## El Paso County Parks

### Agenda Item Summary Form

**Agenda Item Title:** Flying Horse North Filing No. 4 PUD Development Plan and Preliminary Amendment and Final Plat

**Agenda Date:** October 9, 2024

20' REGIONAL TRAIL EASEMENT
BOOK 2981, PAGE 114

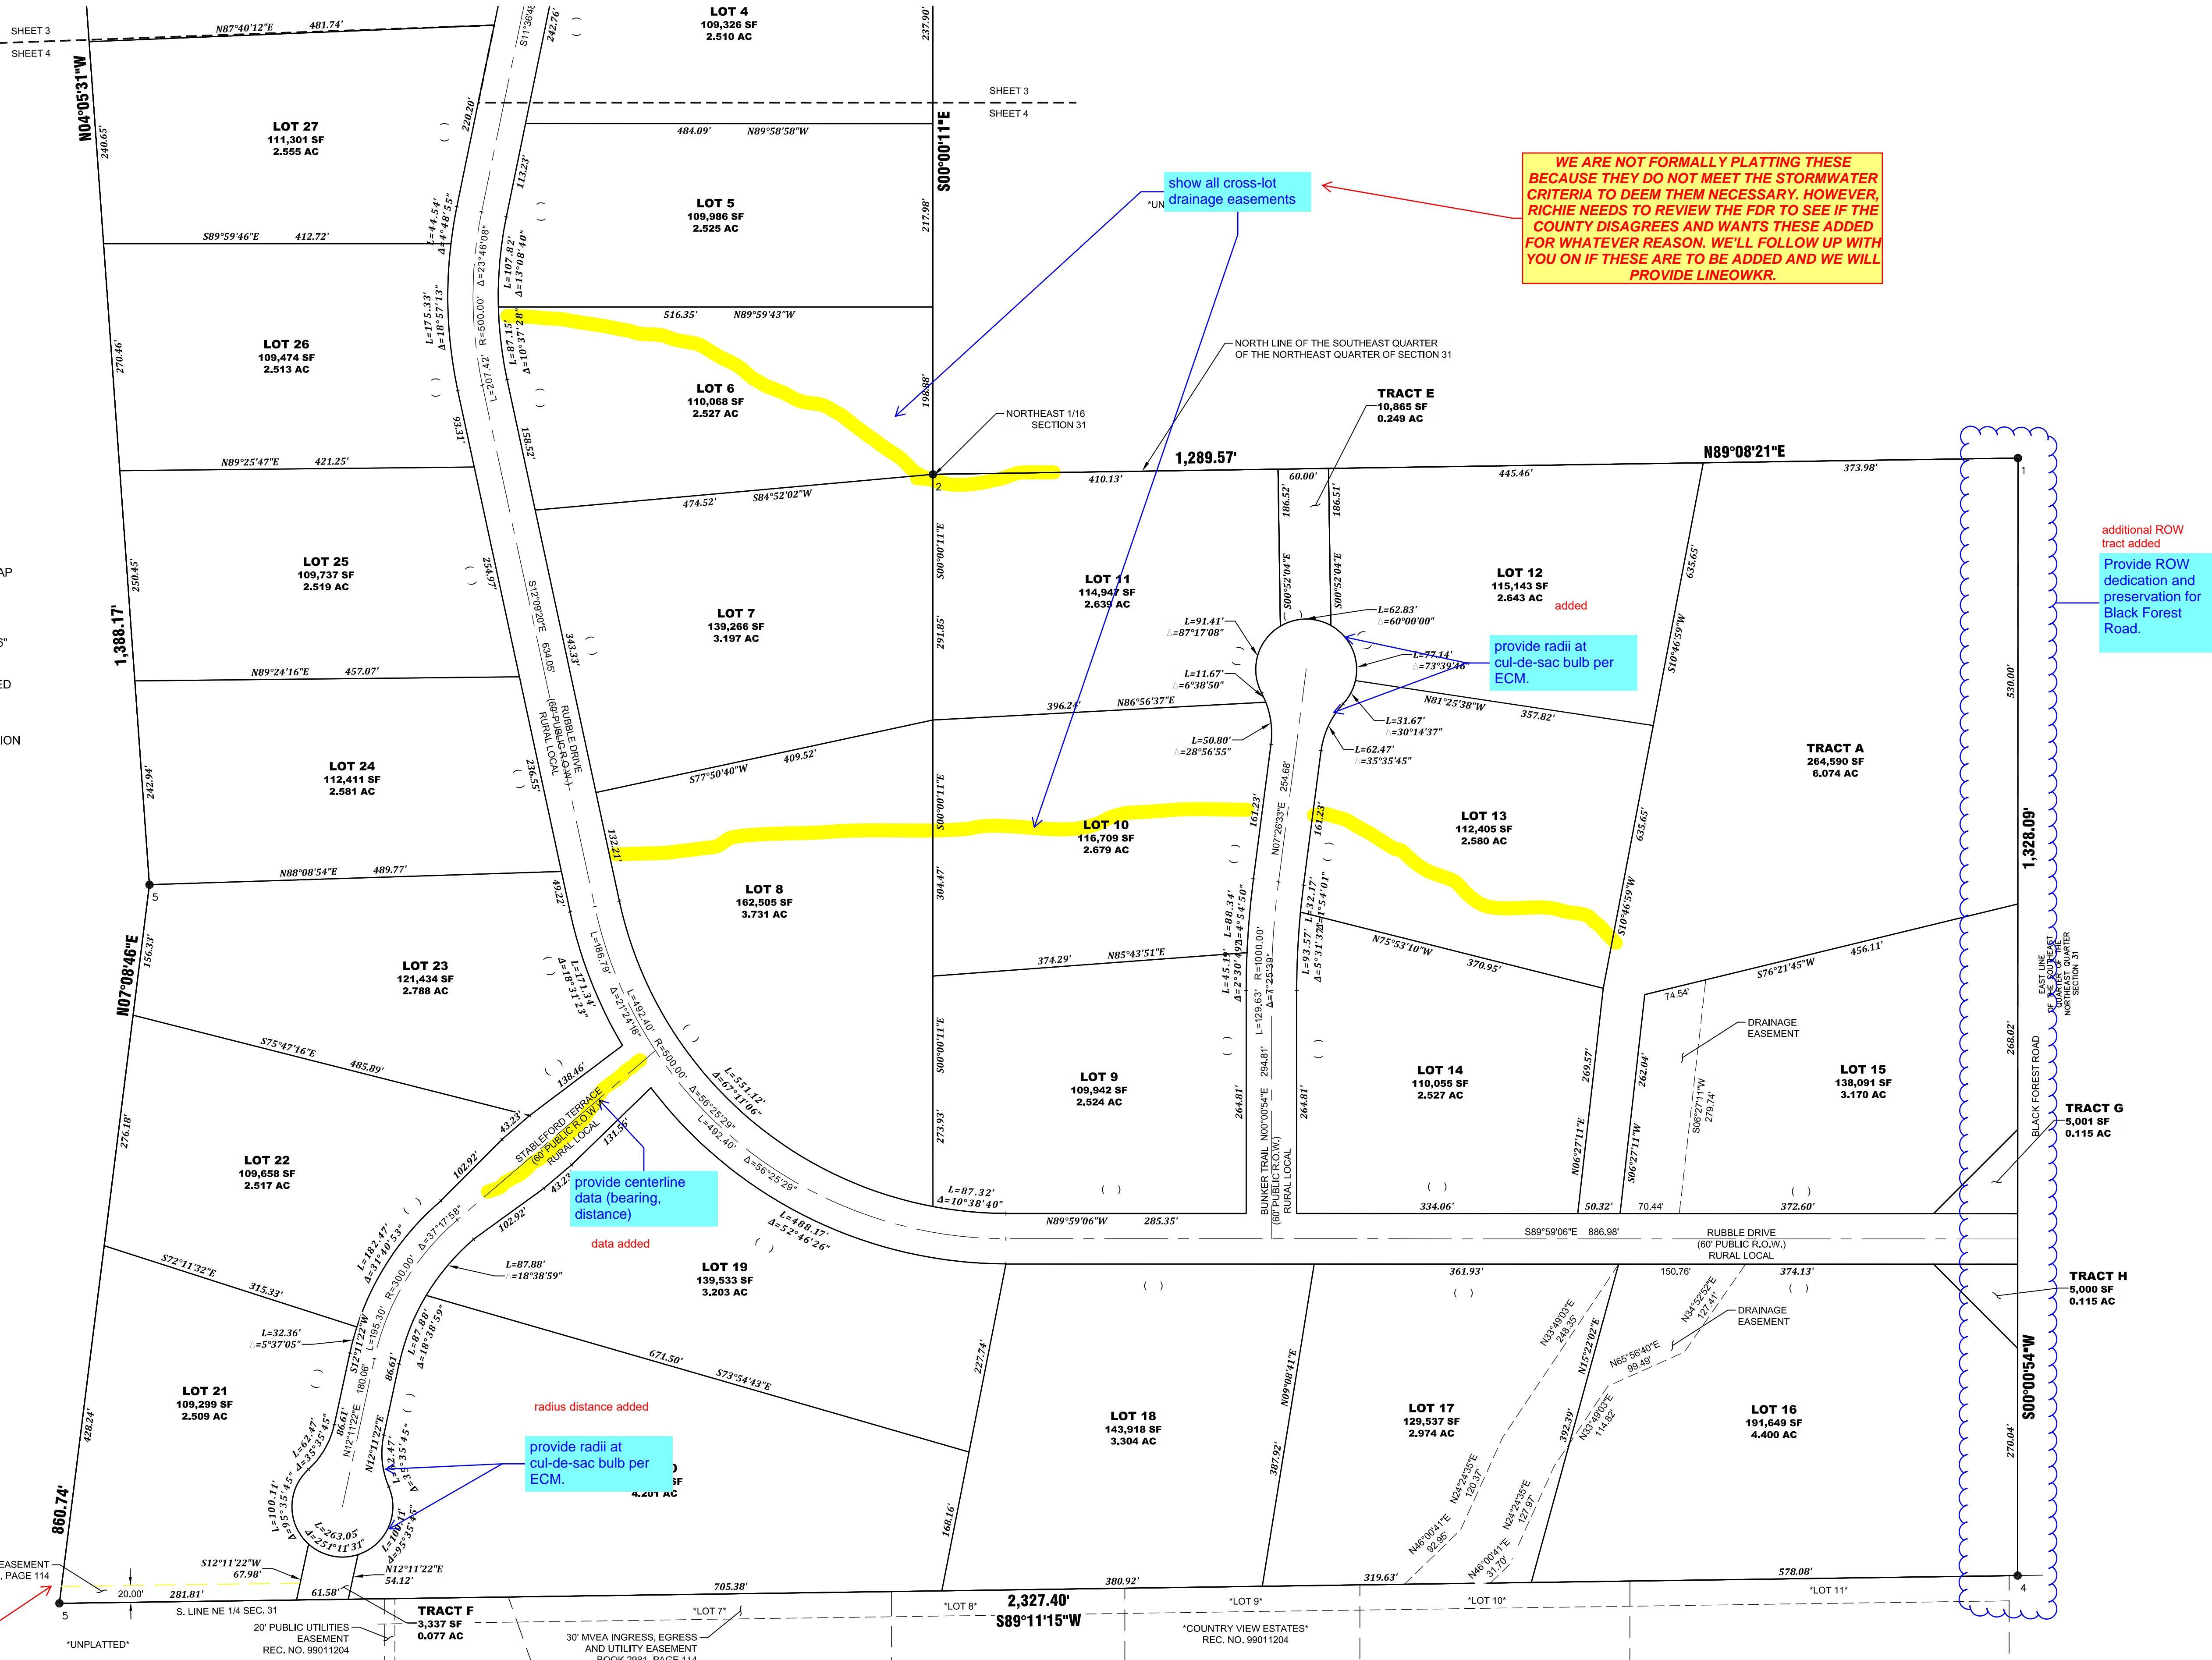
Lastly, the submitted PUD Development Plan and Preliminary Plan Amendment and Final Plat both show a "20' Regional Trail Easement" located at the far southwestern corner of Filing No. 4. A conversation with HR Green revealed that this is actually an internal trail that will connect to the Fox Run Regional Trail and therefore should not be identified as a regional trail, nor an easement dedicated to El Paso County. However, the Trails Exhibit does show the Fox Run Regional Trail running east-west through the northern portion of Filing No. 4, along Old Stagecoach Road. As such, staff requires a 25' public trail easement to be located on the southern side of Old Stagecoach Road, through Lots 31-33, and dedicated to El Paso County on this Final Plat.
